Portishead Branch Line (MetroWest Phase 1)

9.31 ExA.FI.D4.V1 – List of consequential amendments arising from removal of Work 16D

**Works 16D – consequential amendments arising from removal
of Work from Schedule of Authorised Works**

This document lists the changes required to Order documentation as a result of the Examining Authority's (ExA) decision of 22 December 2020 (PD-012) to permit the removal of Work 16D from the proposed DCO Scheme.

Drawing: EASTON-IN-GORDANO FLOOD MITIGATION PLAN

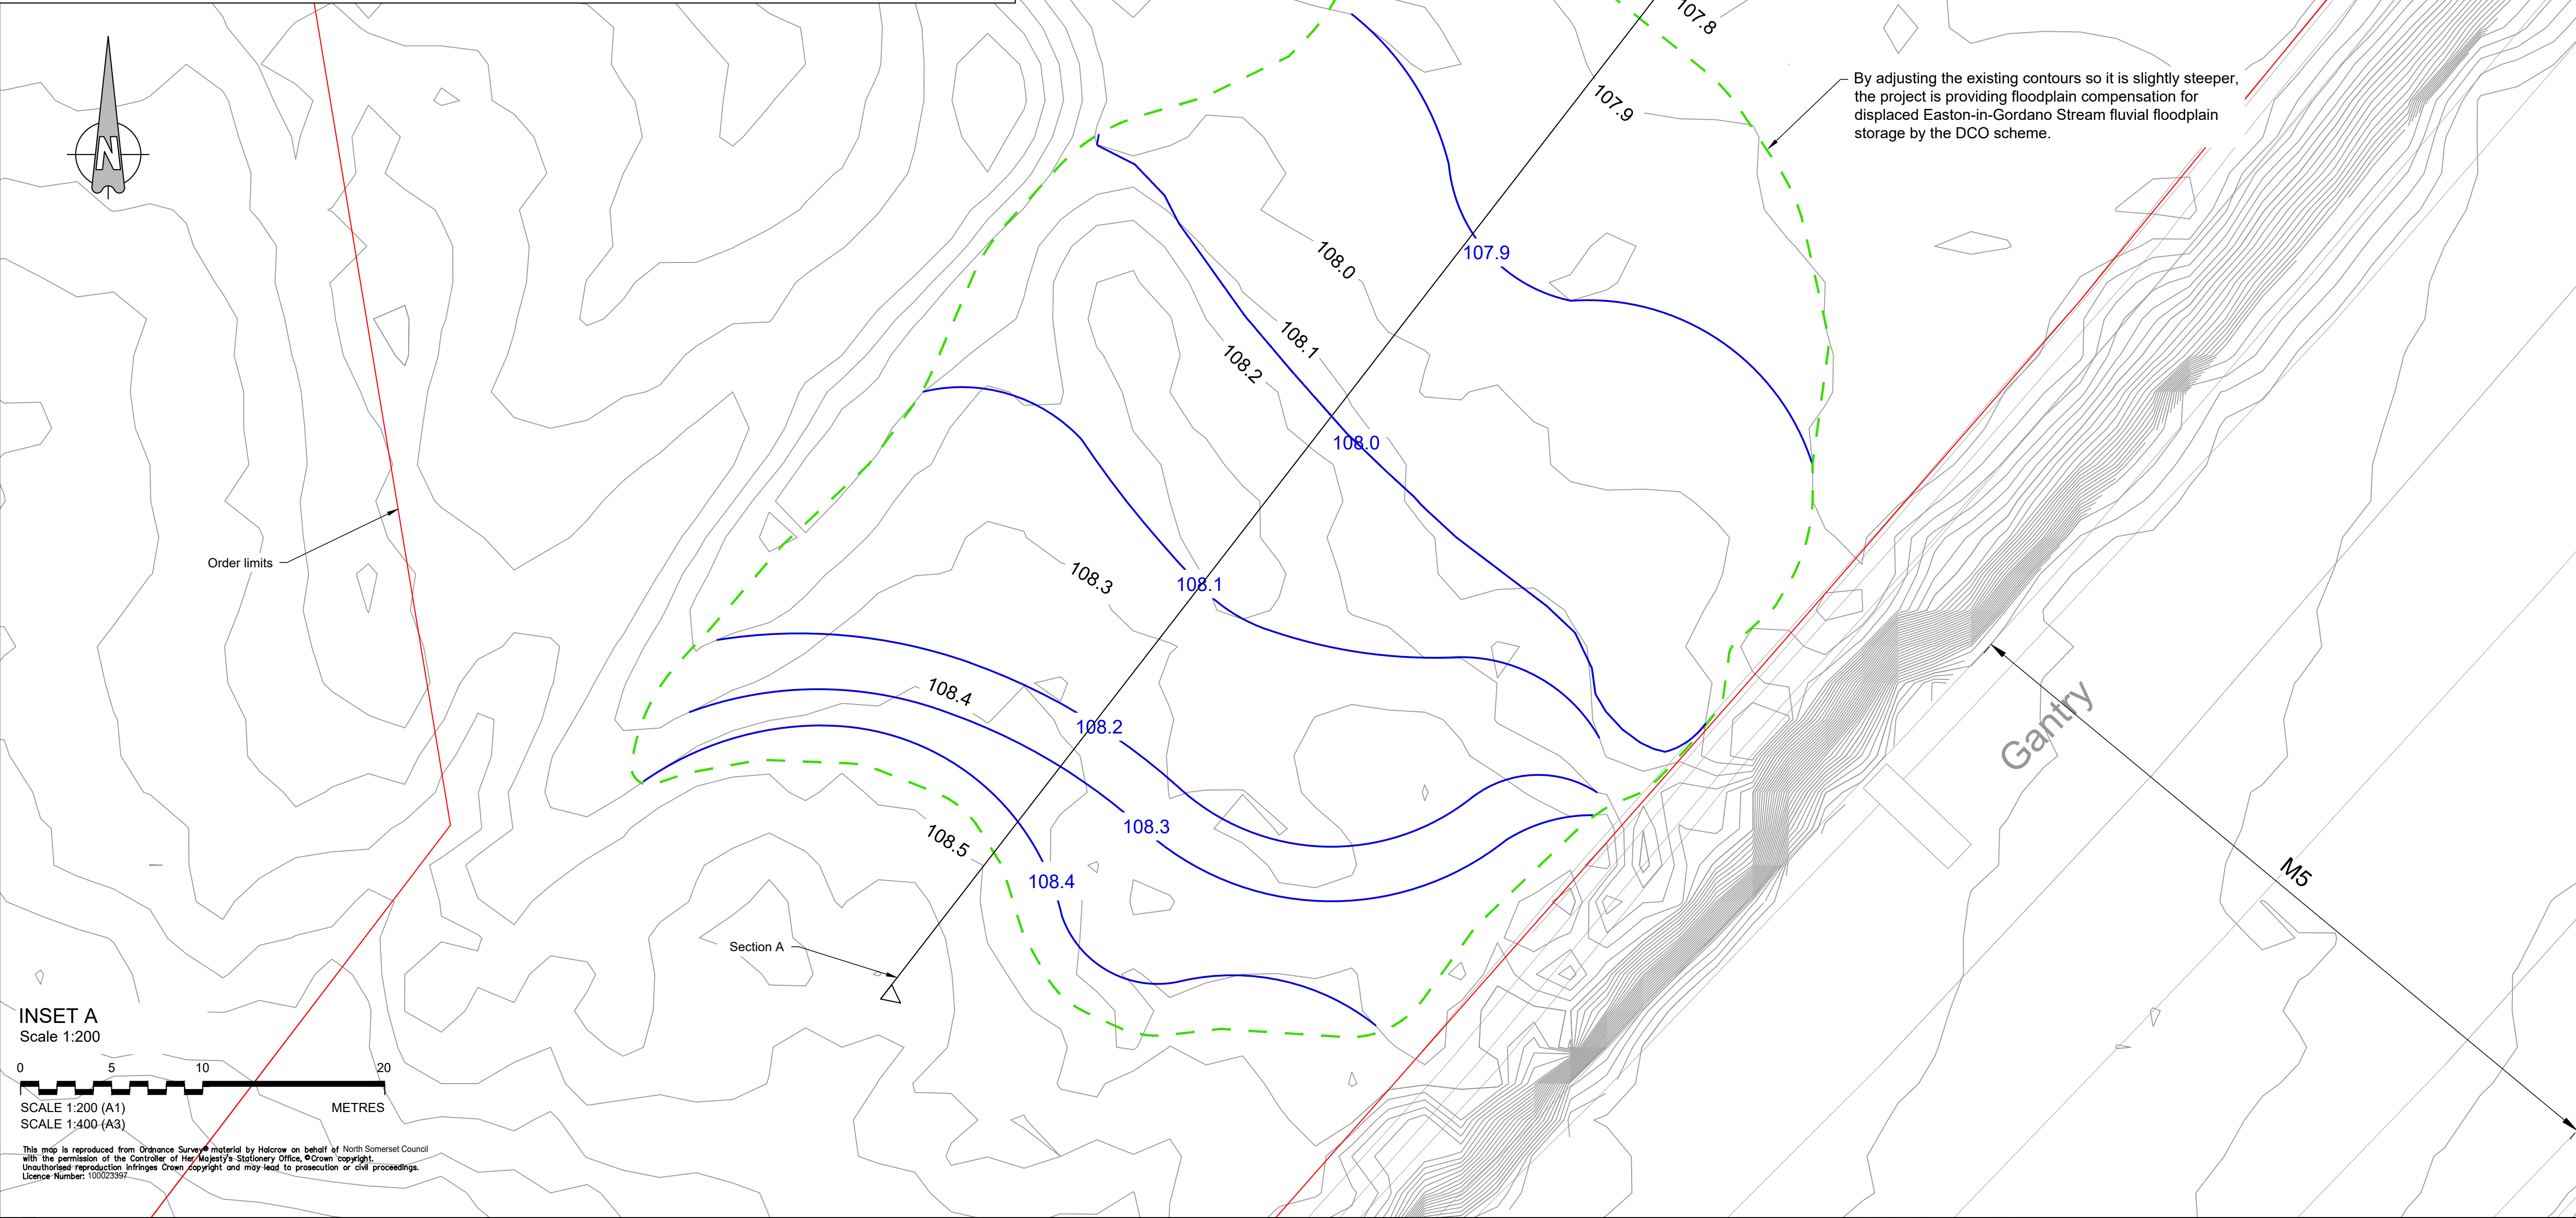
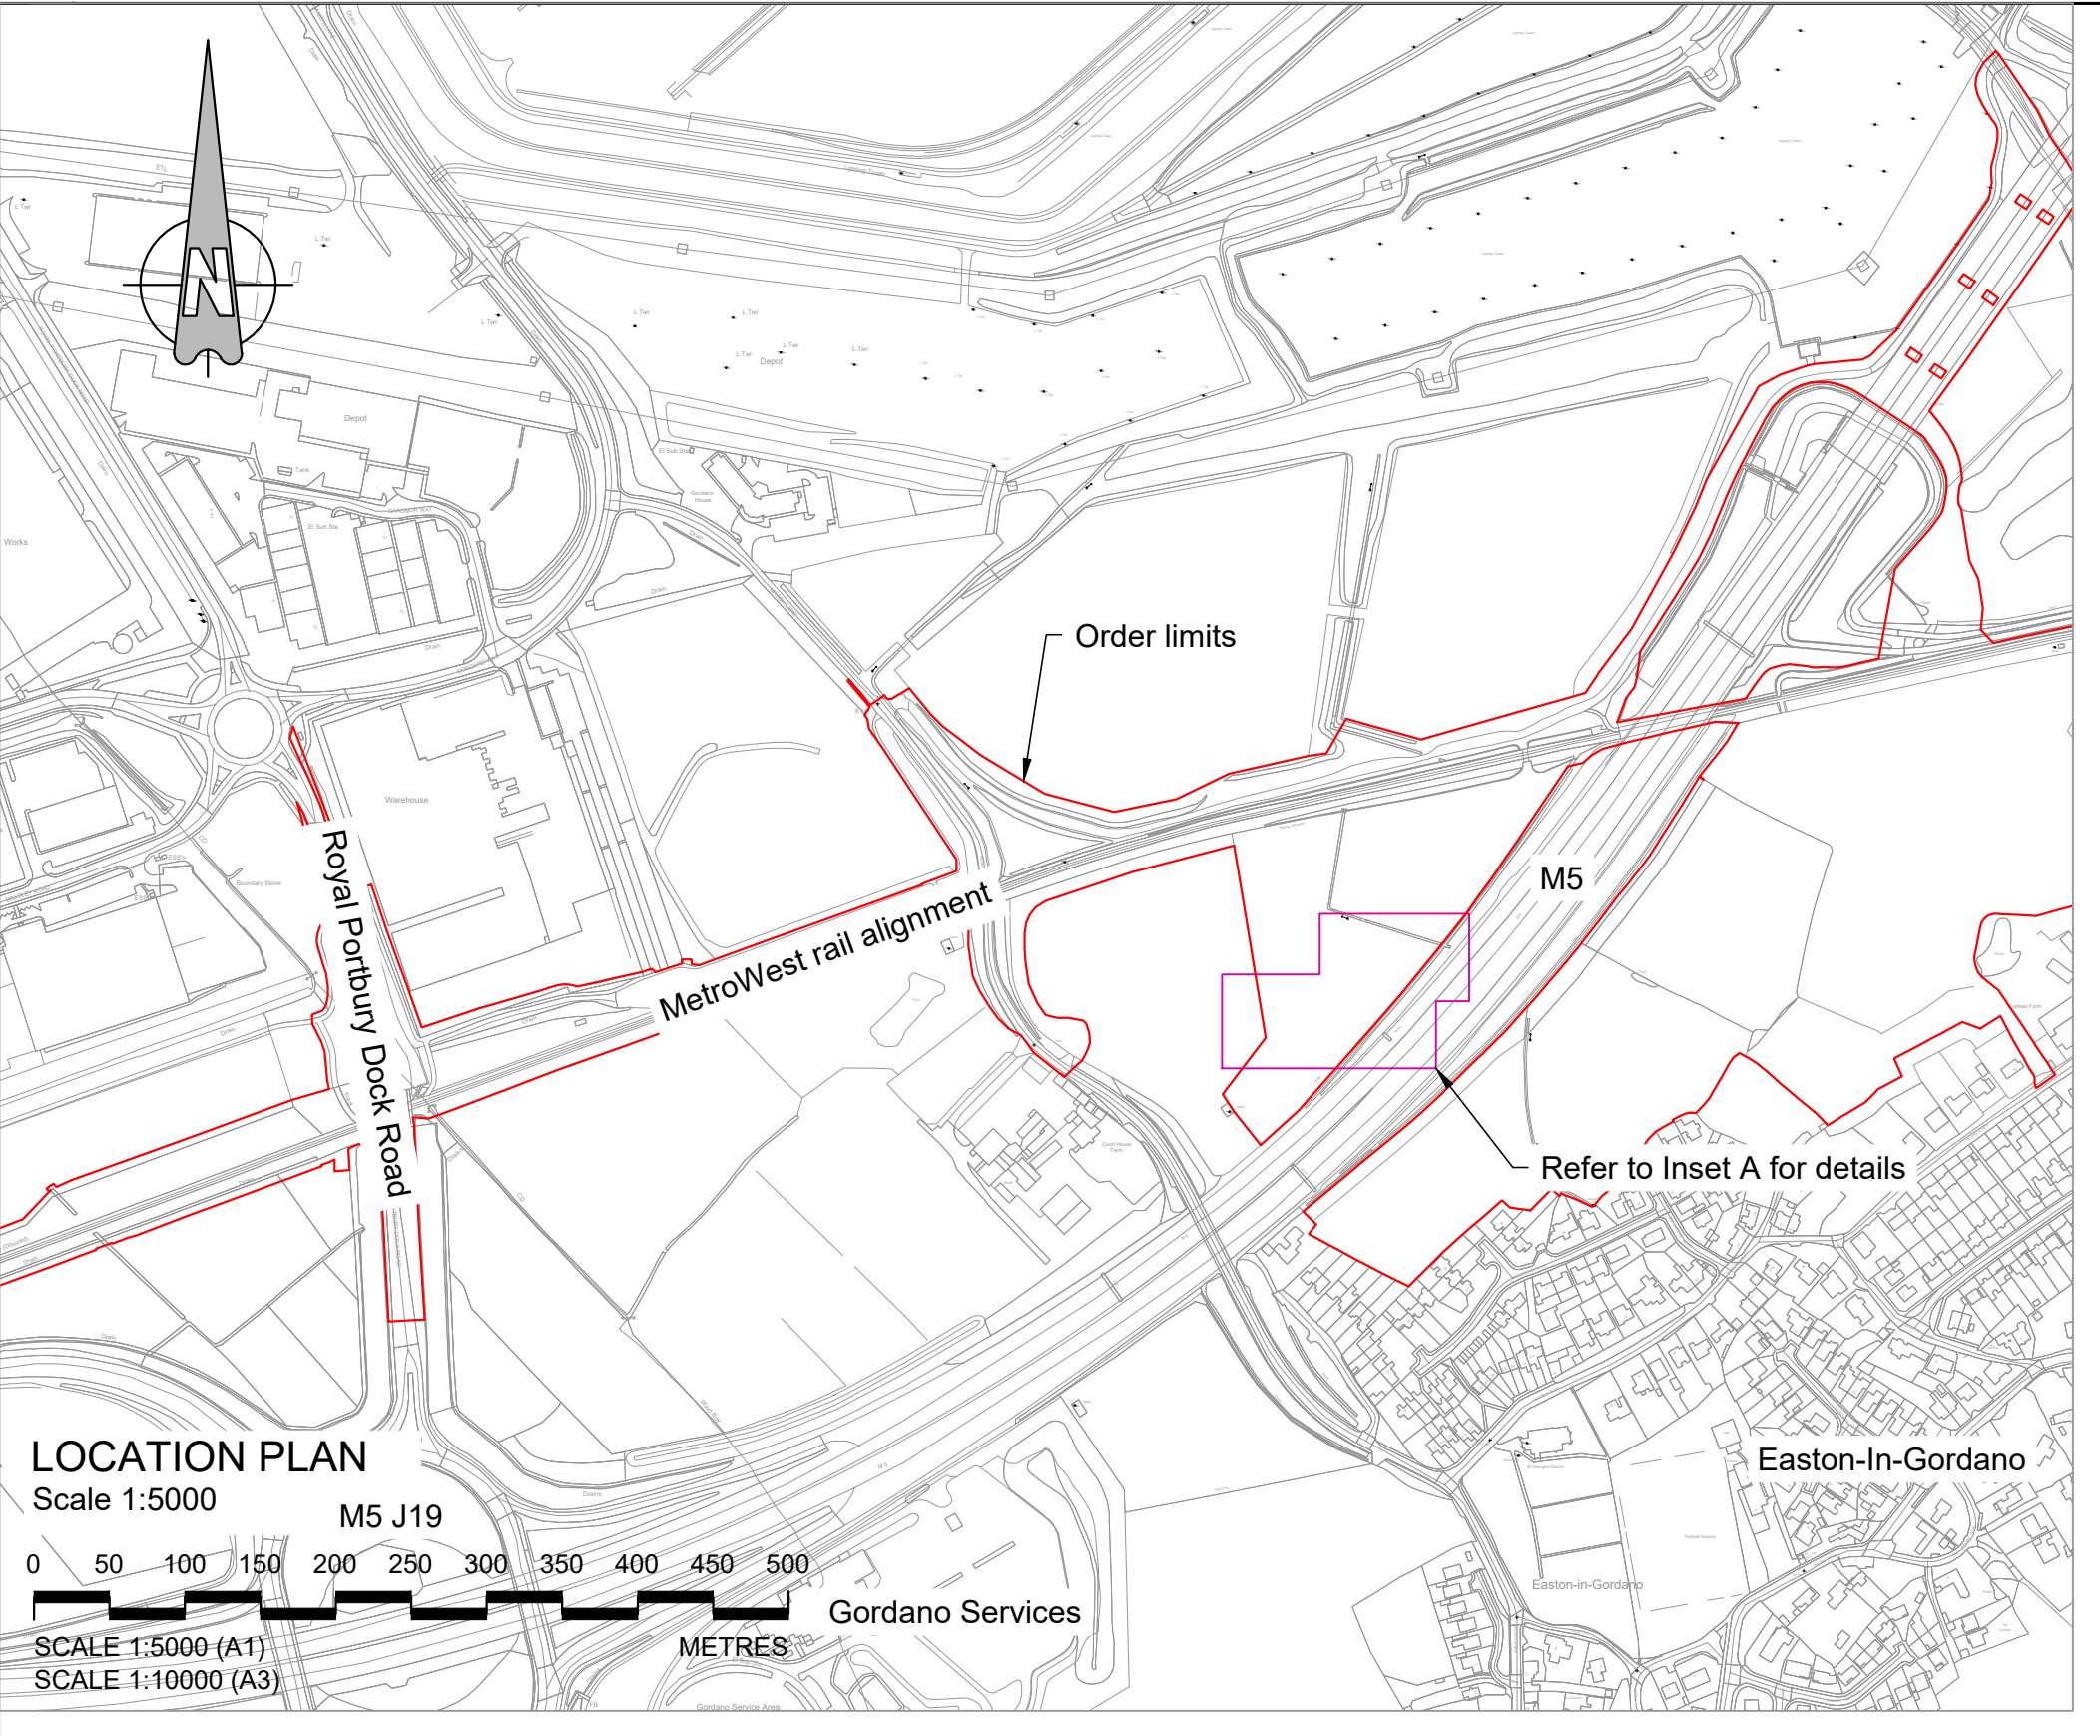
- Works Plan Sheet 5	References to Works No. 16D Eastern-in-Gordano Flood Mitigation	This will need to be amended so that the references to Works No. 16D Eastern-in-Gordano Flood Mitigation work is removed
<i>Railway Landscape Plans (Application Document 2.10: APP-017)</i>

Drawing
RAILWAY LANDSCAPE PLANS
(DISUSED LINE)
SHEET 6 OF 8

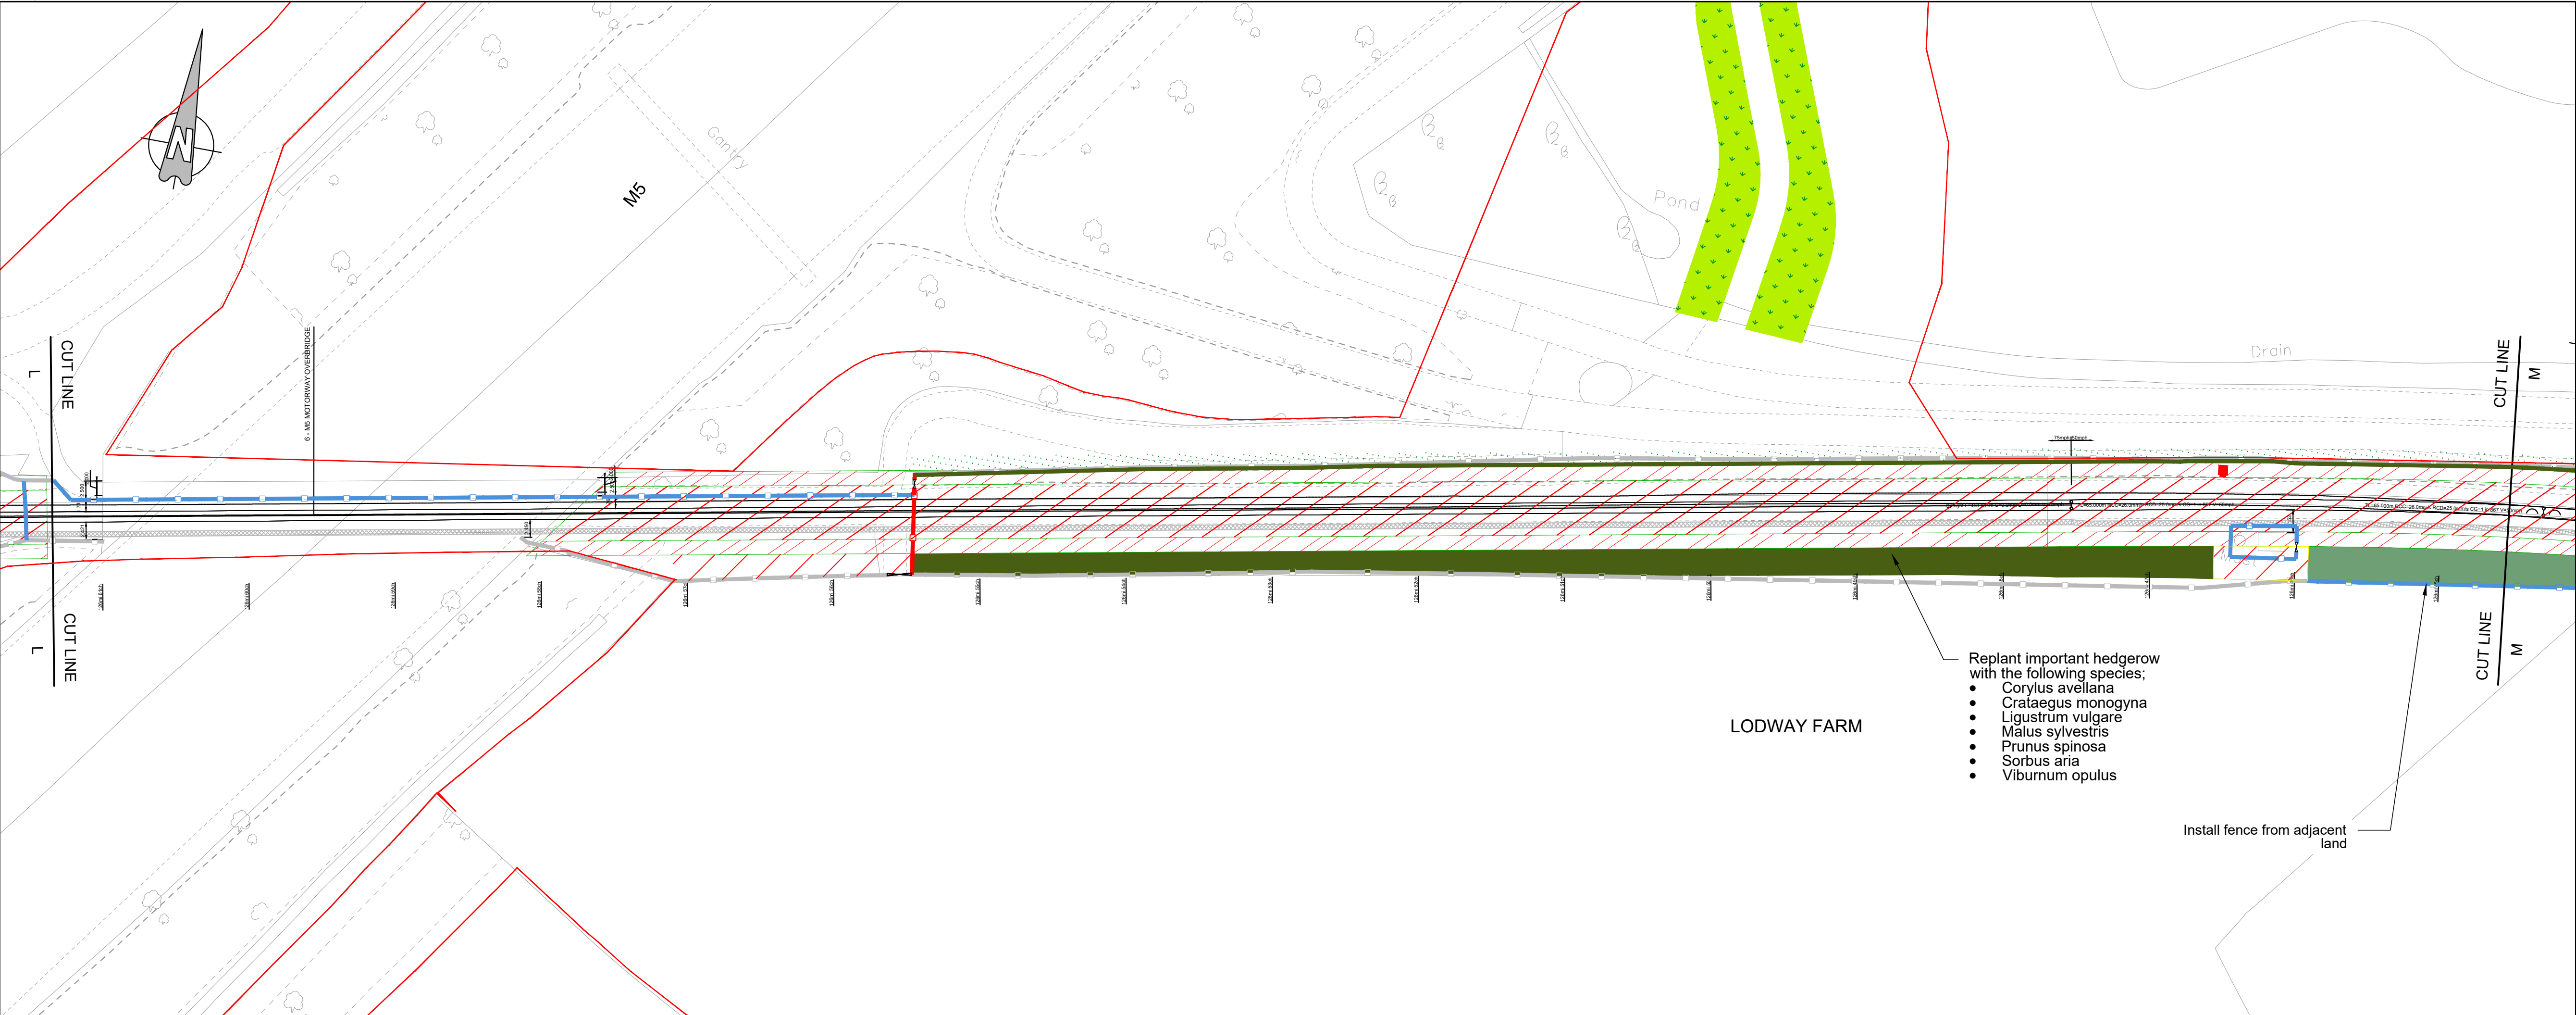
Sheet 6	Landscaping works shown between cut lines K – L	May need to be updated if further landscaping works are required as a result of the changes
<i>Environmental Masterplan (Application Document 2.53: App-045)</i>
